Application No: EP/16/21/PL
Site Address: Land East of 1 The Way East Preston BN16 1QJ
Description of works: Replacement garage. This site is in CIL Zone 4 (Zero Rated) as other development.

Thank you for your internet representation made on 5th March 2021 which has been recorded as an objection with the comments as follows:

Drawing Title:
Topographical Plans

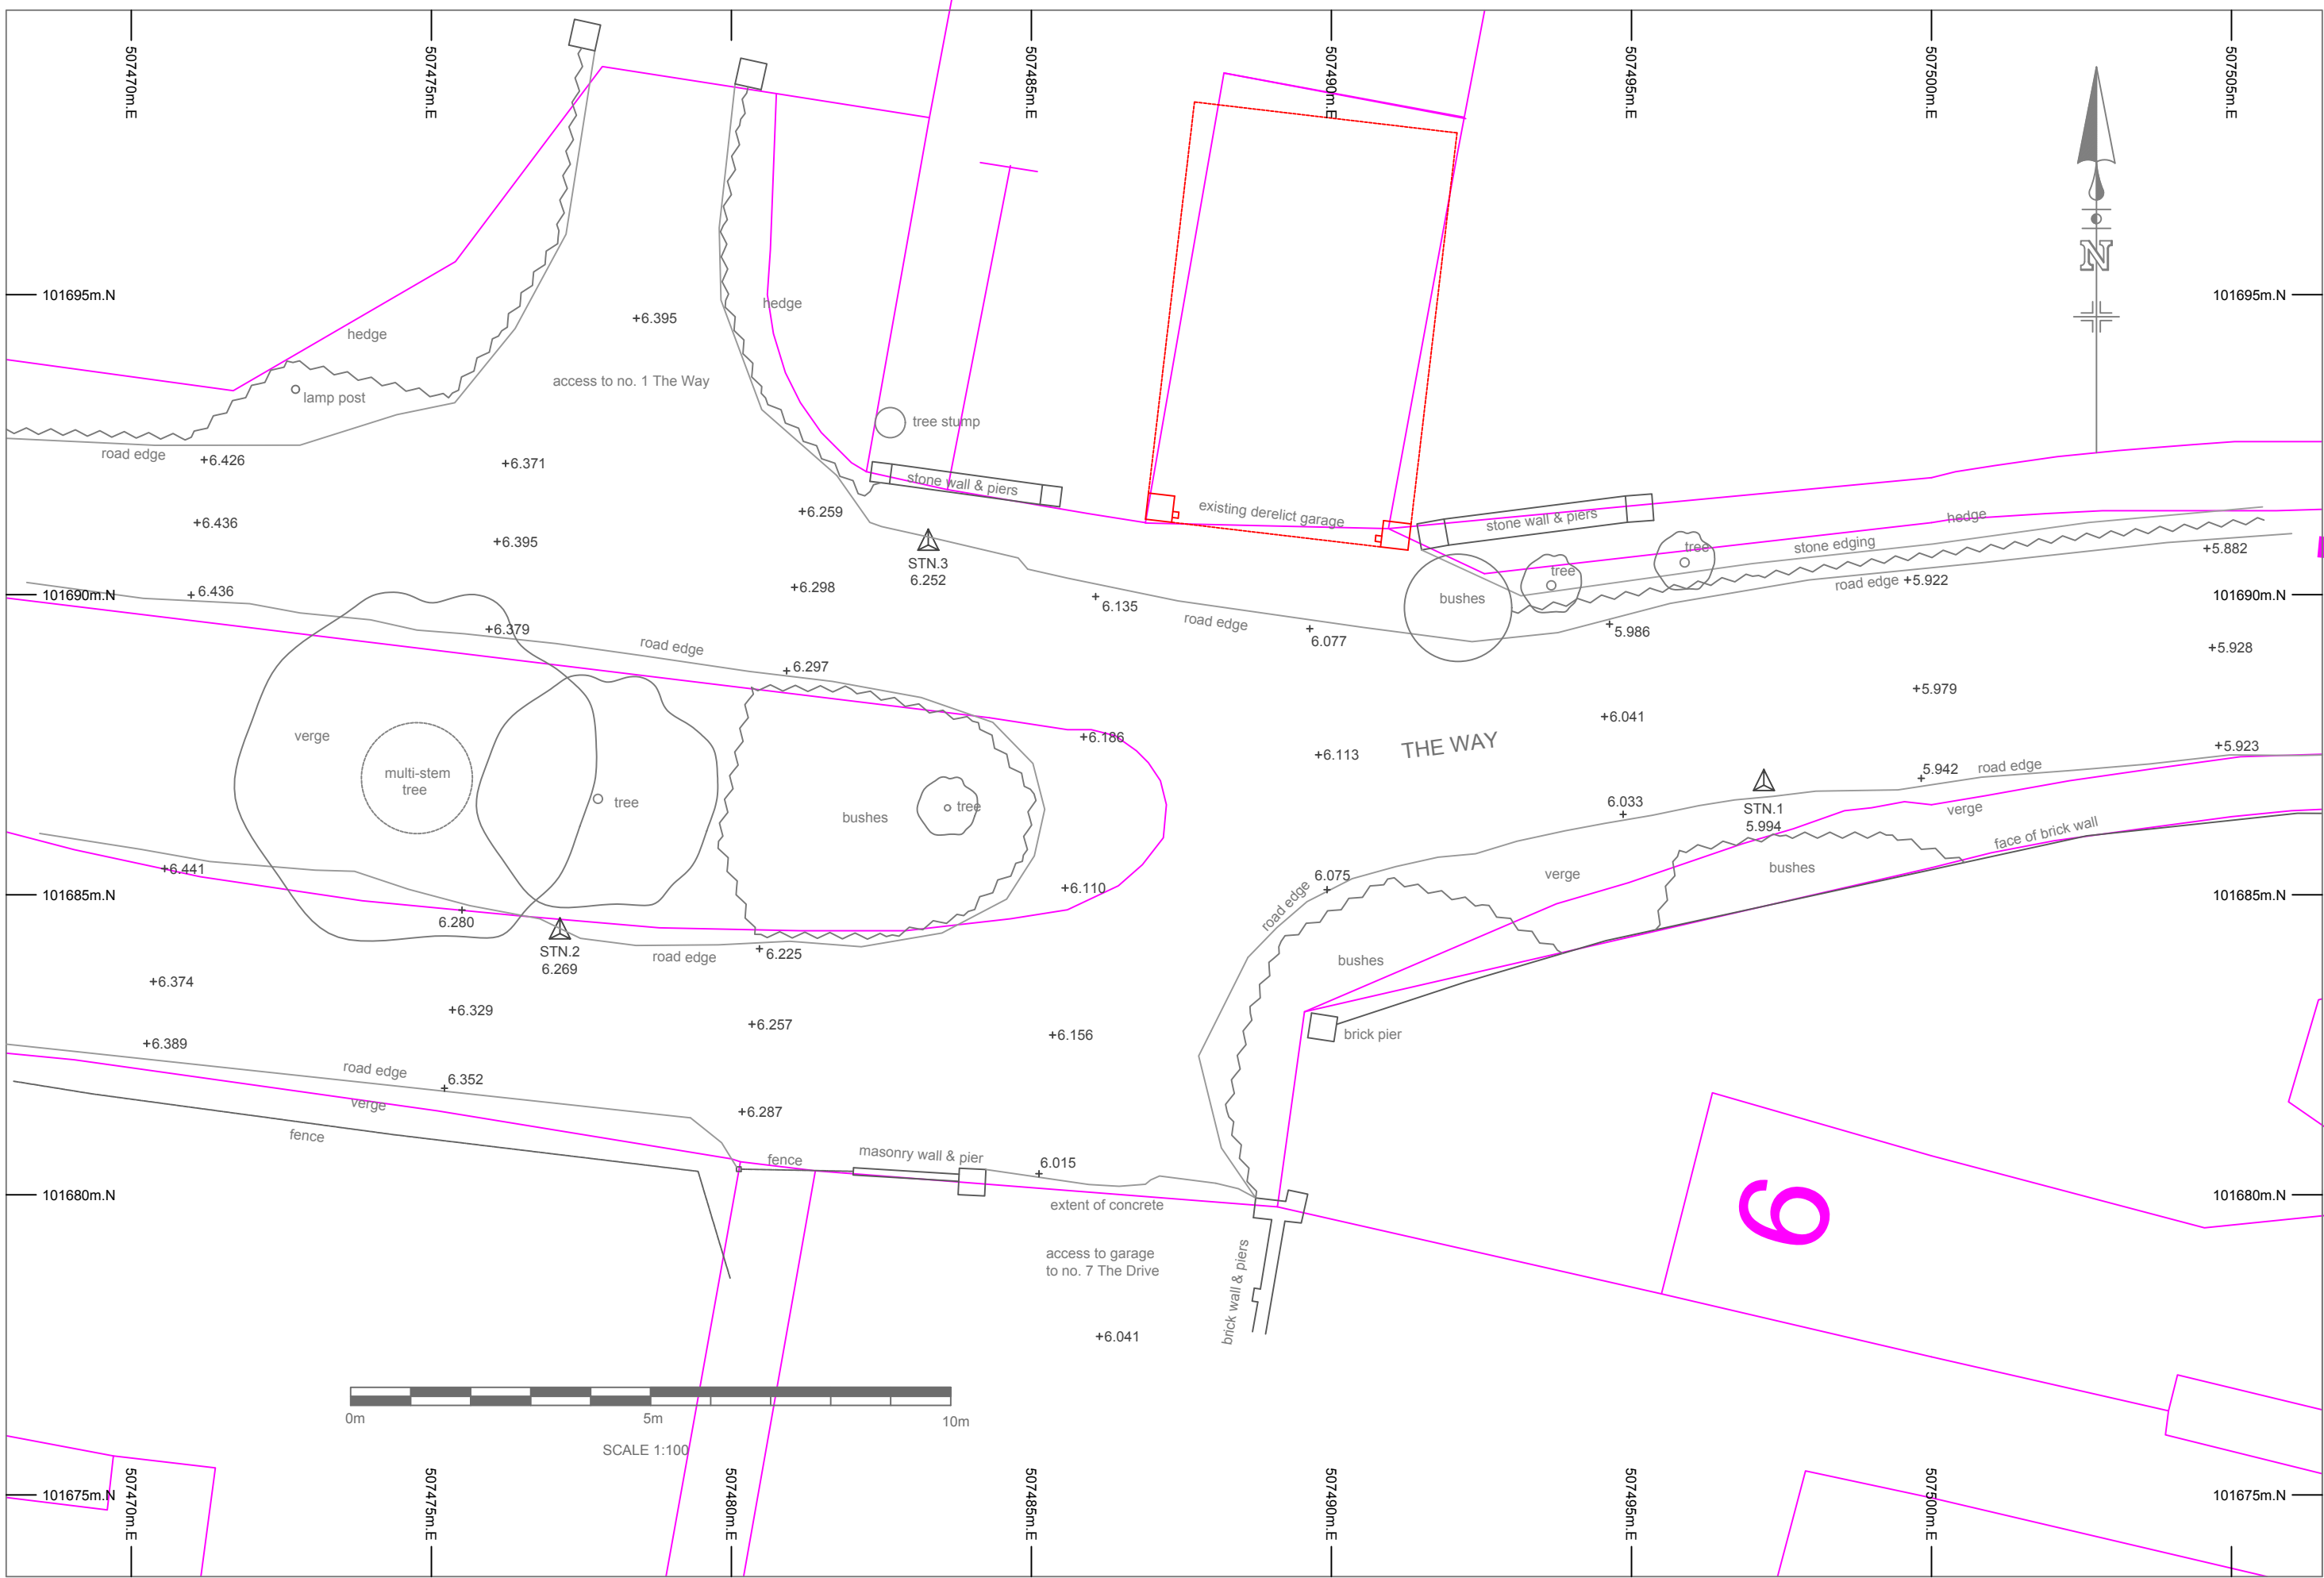
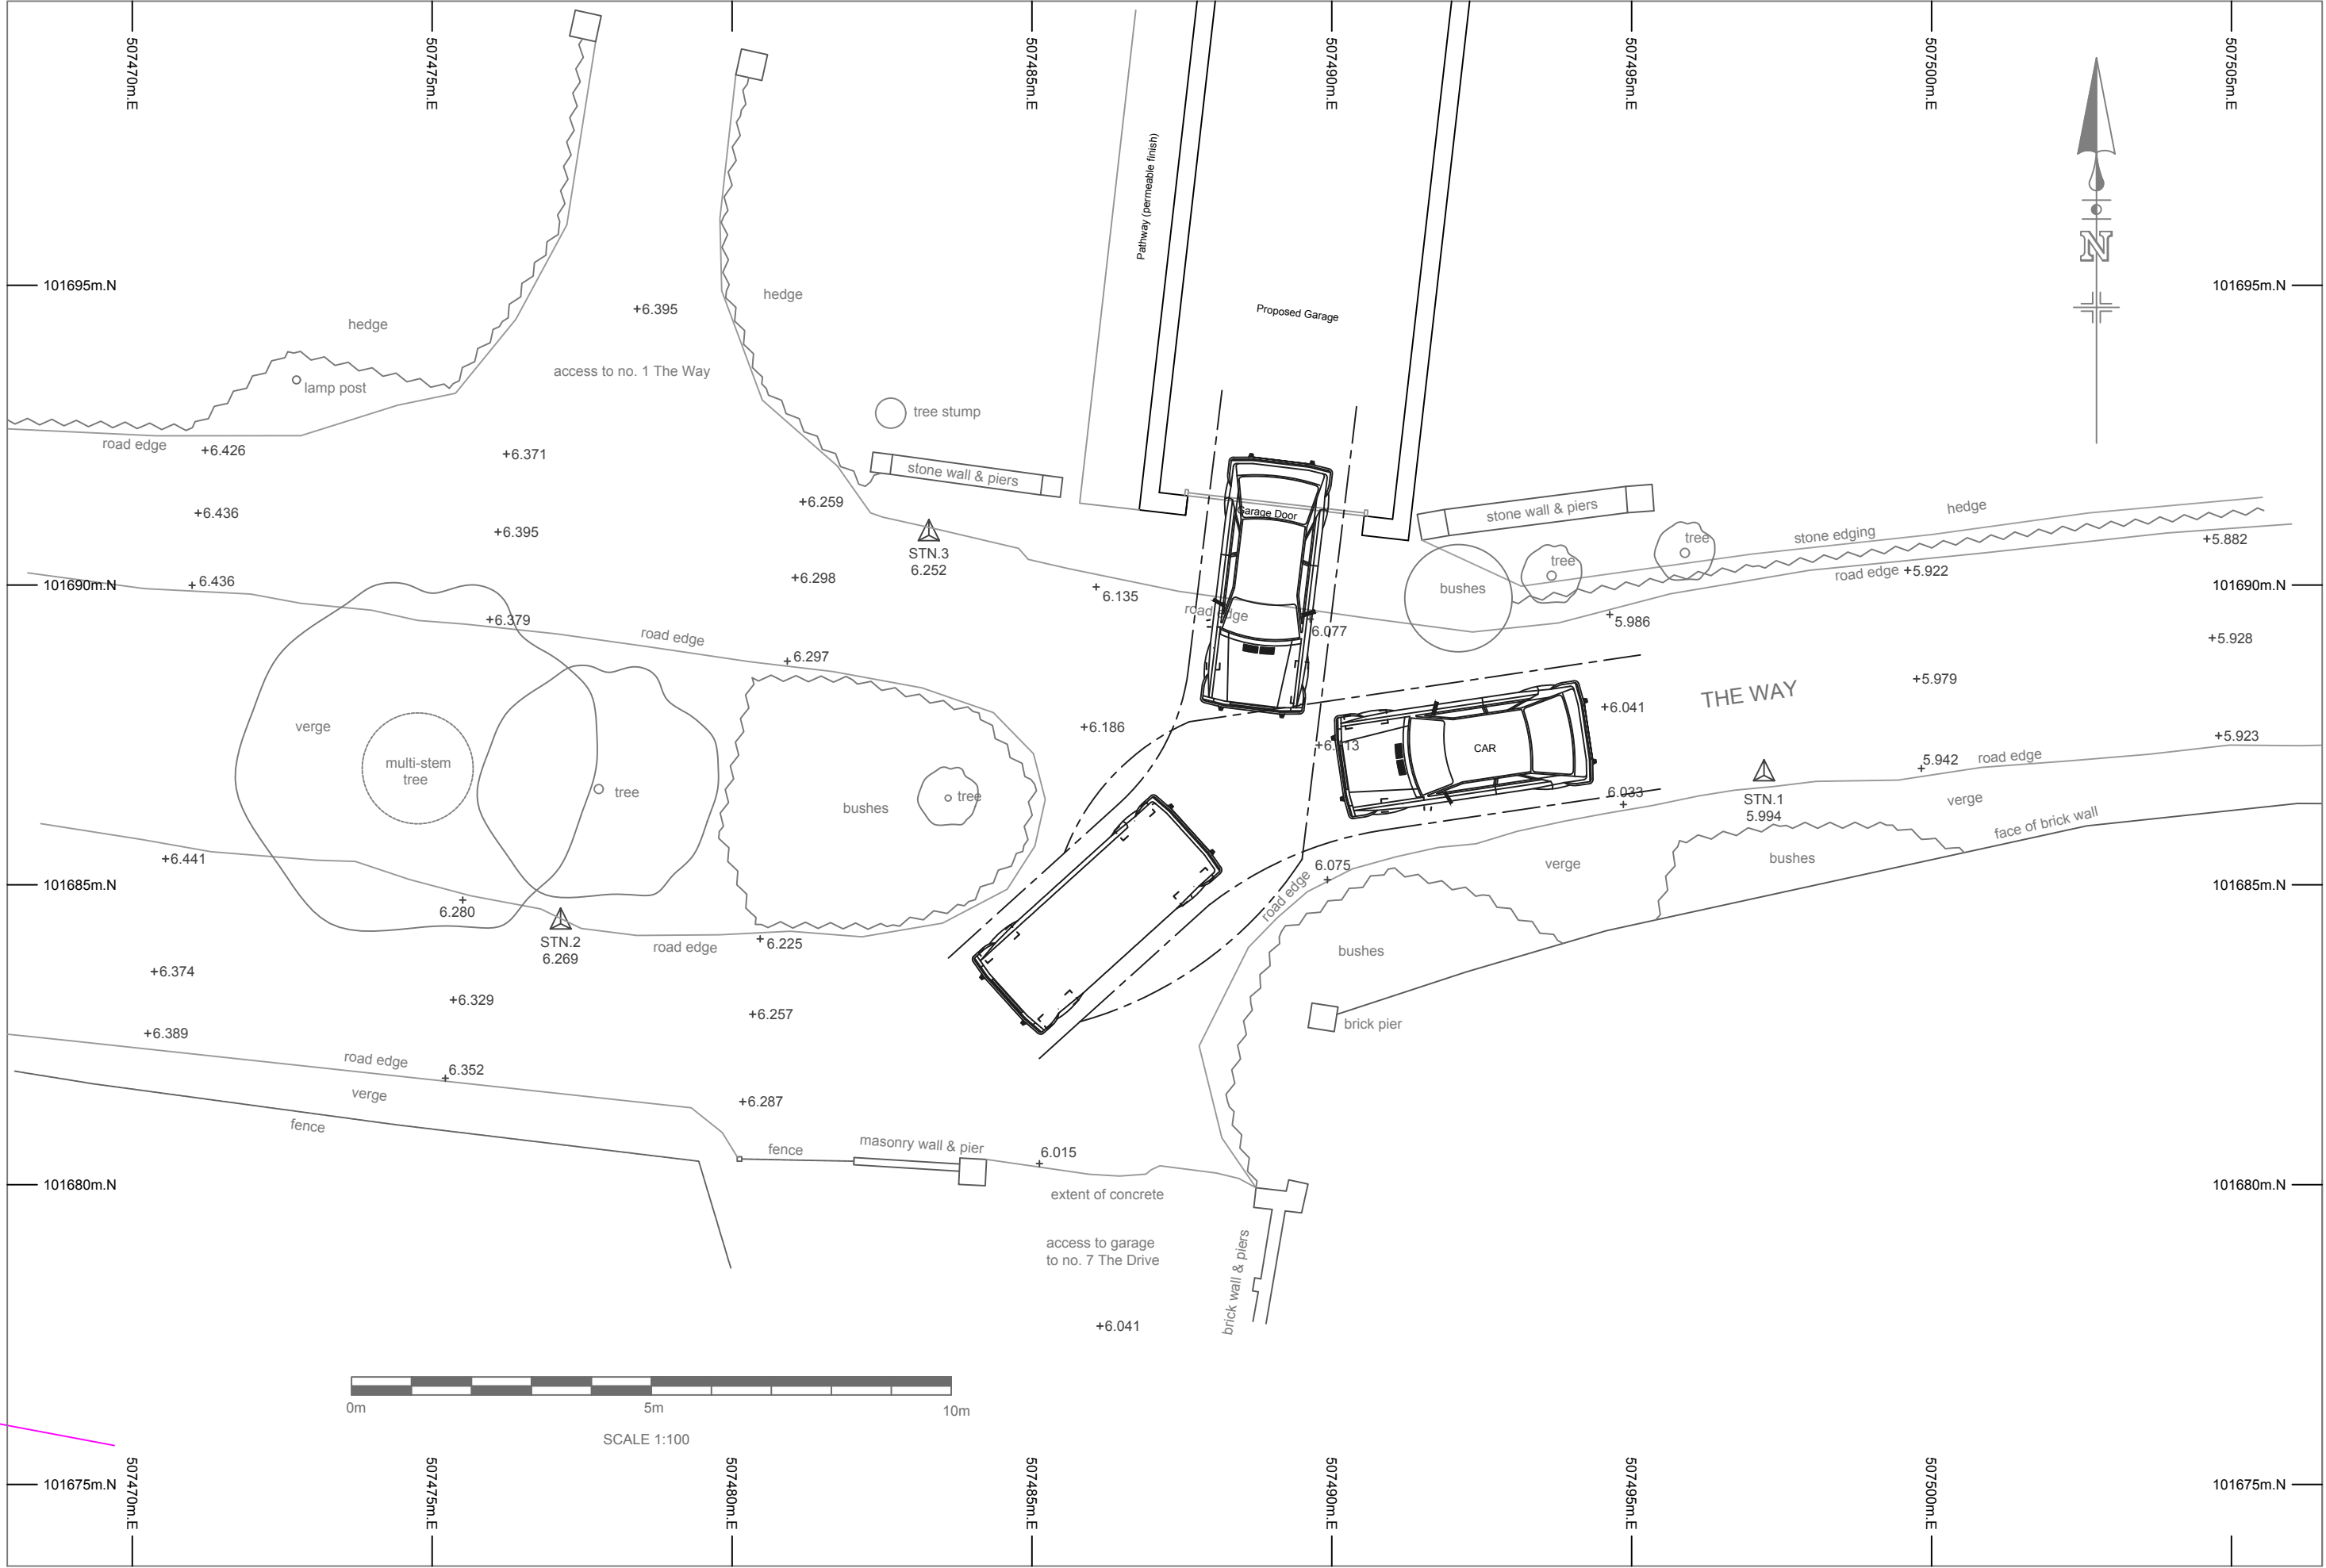
- to note: the current application shows the boundary between the site and our land to be to the west of the drainage ditch. We have conveyance and original planning approval plans for our property (dated 1963) confirming that the boundary is the middle of the ditch
